ENG-PUDSP21005-R1-TIS.pdf Markup Summary

Figure 7

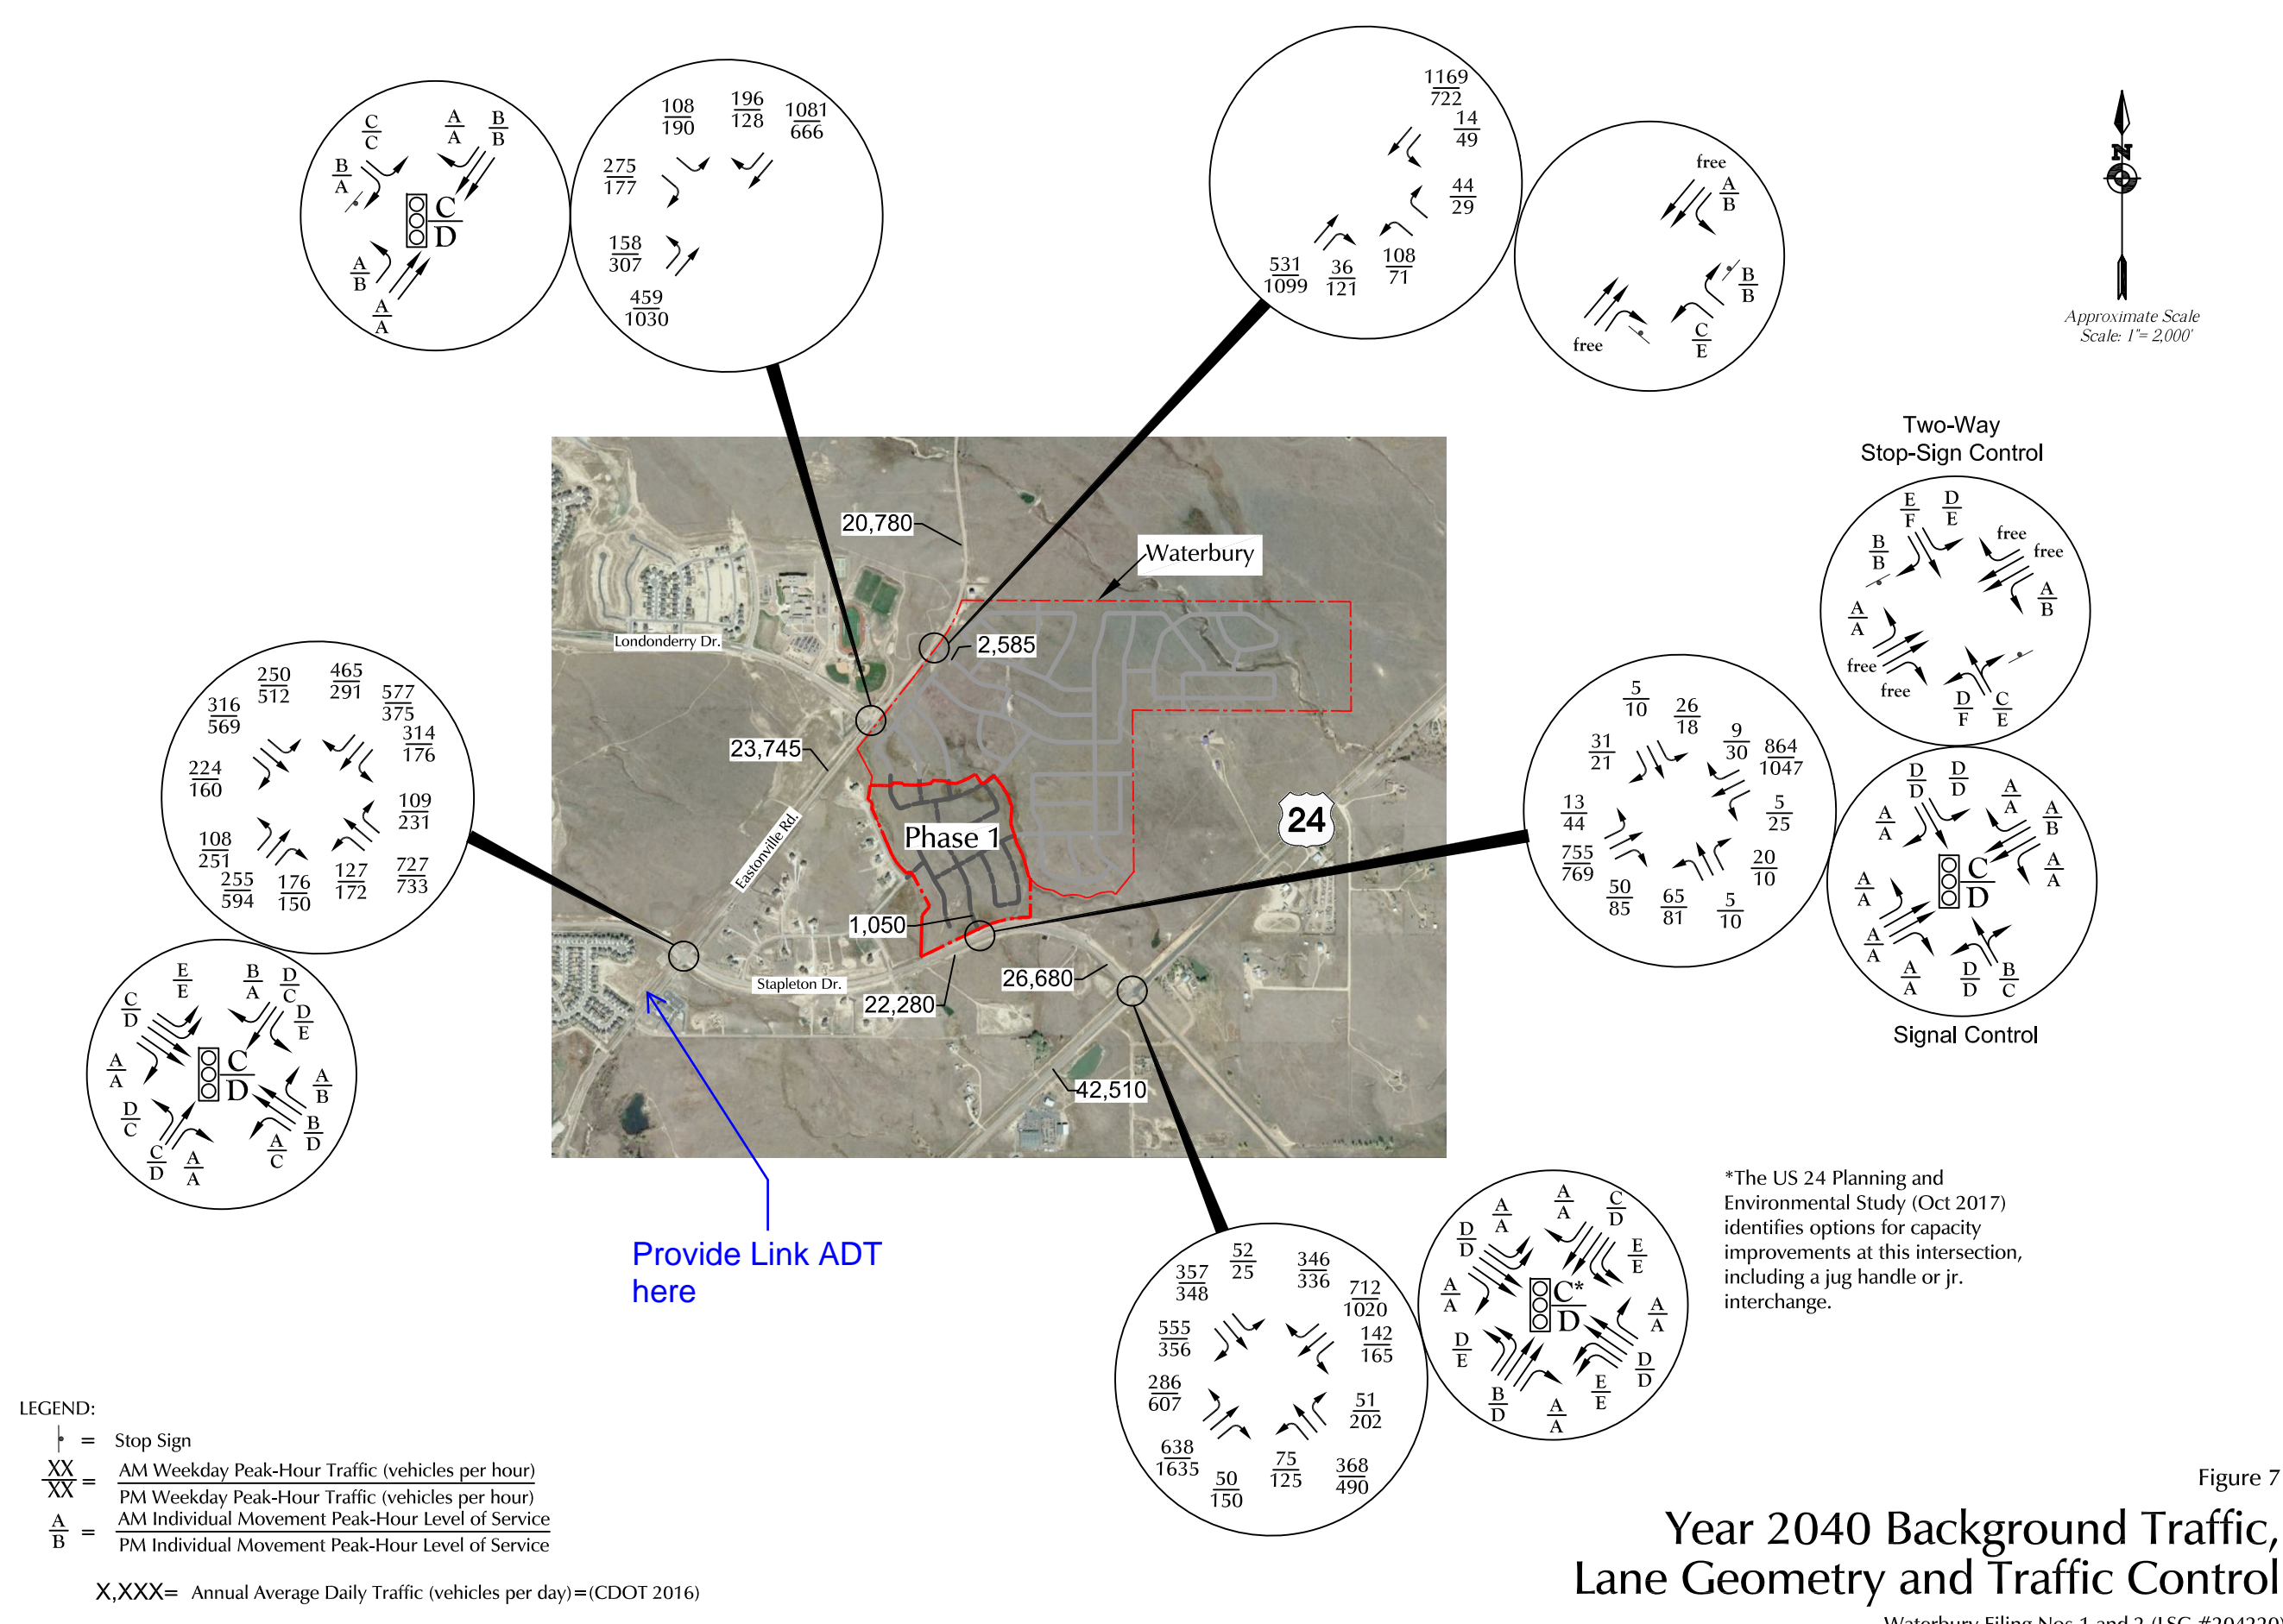
Total? Numbers don't match Figure 7.
